DELEGATED DETAILS DECISION

Report of the Head of Planning, Building Control, Sport & Green Spaces

Address RAF WEST RUSLIP HIGH ROAD ICKENHAM

LBH Ref Nos: **38402/APP/2015/851**

- MAIN FACING BRICK - IBSTOCK - SEVENOAKS YELLOW
- RENDER - K REND (Or similar) - OFF WHITE
- MARLEY ETERNIT EQUITONE TEXTURA - TG601 BUTTERWICK

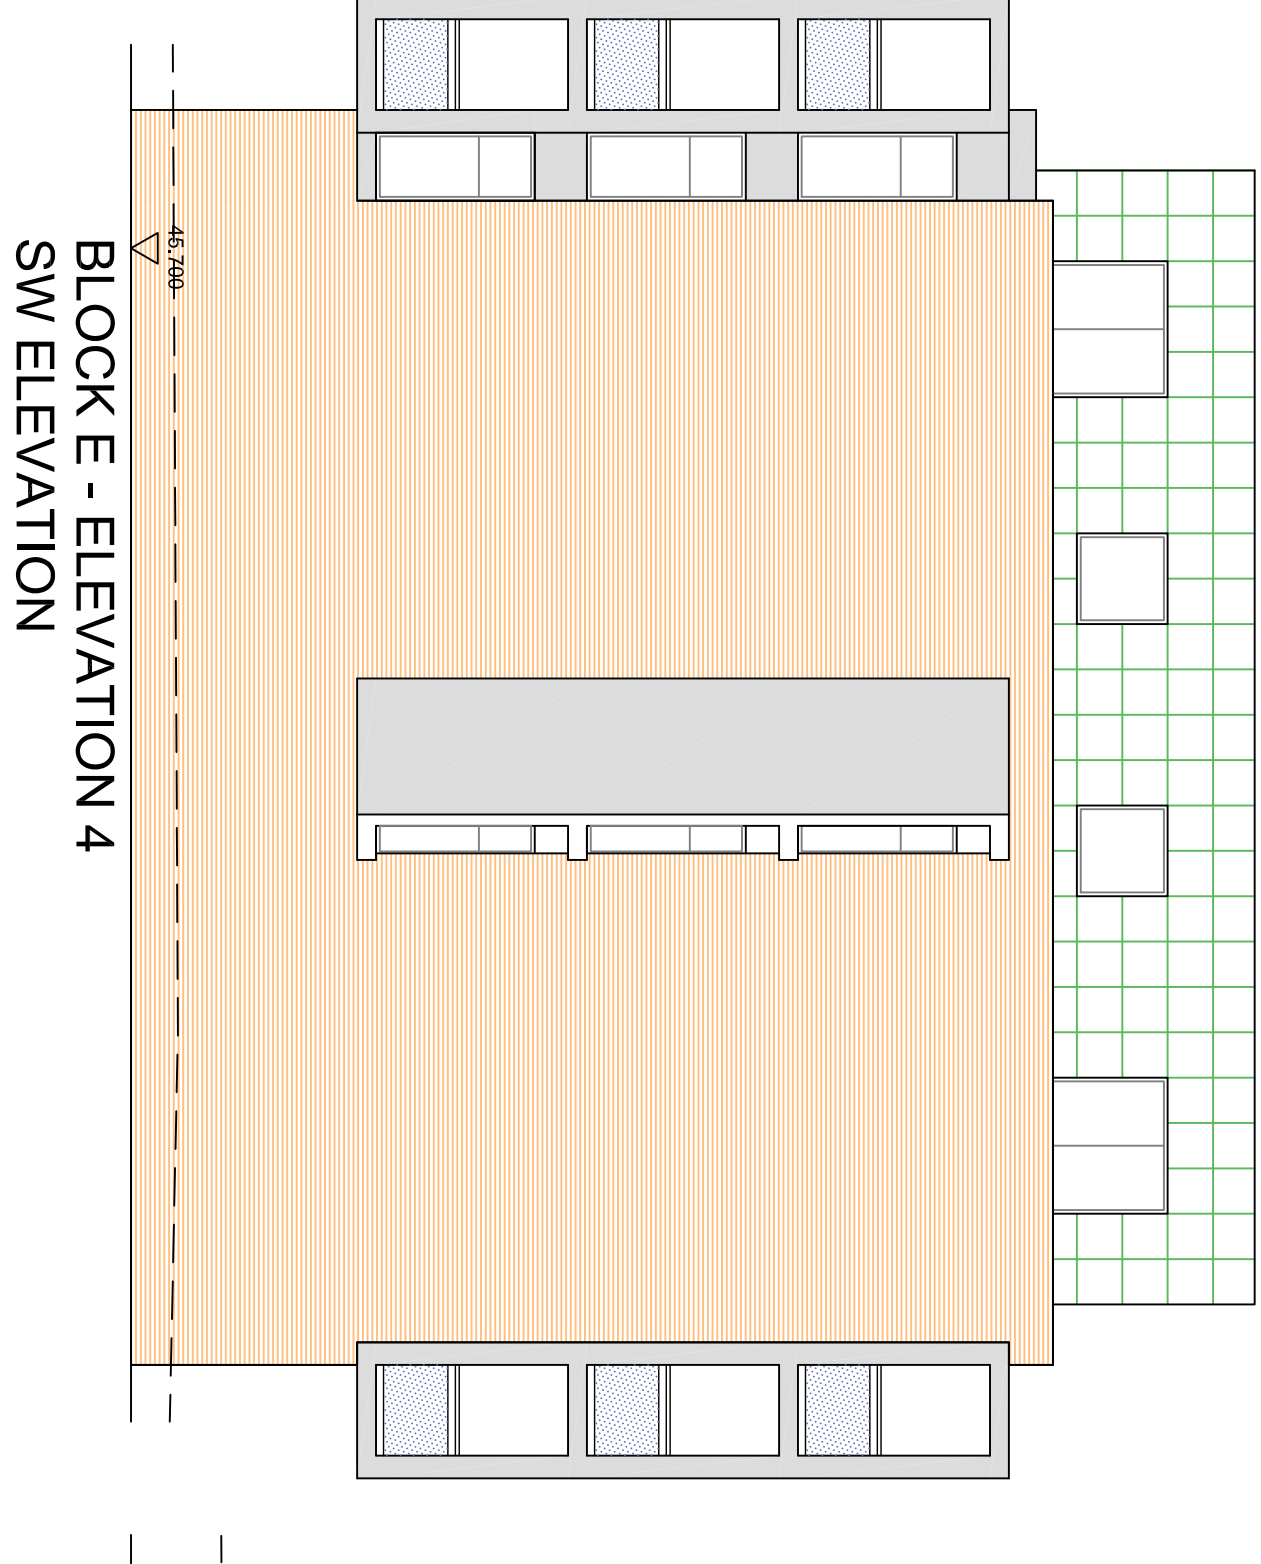
There are, however, concerns re the materials for the two blocks of flats. Whilst these appear to be the same as approved for the existing block adjacent to the

station, this structure as built does now appear to be overly prominent in the street scheme, not only because of its height and bulk but also because of its light coloured rather bland looking materials. If possible, the use of these for this phase should be reconsidered, and a darker more textured brick and a more recessive cladding colour for the upper floor used.

I still think the proposed yellow bricks are not the best, the bricks used on the other side of the site look better, with more texture and a subtle variety in colour. But I don't know how far we can object to the bricks as proposed if we have agreed them for use on this part of the site previously.

The revised proposed brick for use on the flats is acceptable and the other changes to the materials for the houses are also acceptable.

Following the Urban Design/Conservation Officer's initial comments, the bricks for the flatted blocks have been amended and are now slightly more textured. The tiles have been approved previously on the adjoining phases. The agent has also confirmed that the weatherboarding on the projecting bays which are only present on 6 houses would be Eternit Cedral, colour - white. The Urban Design/Conservation Officer is satisfied with the proposed materials.
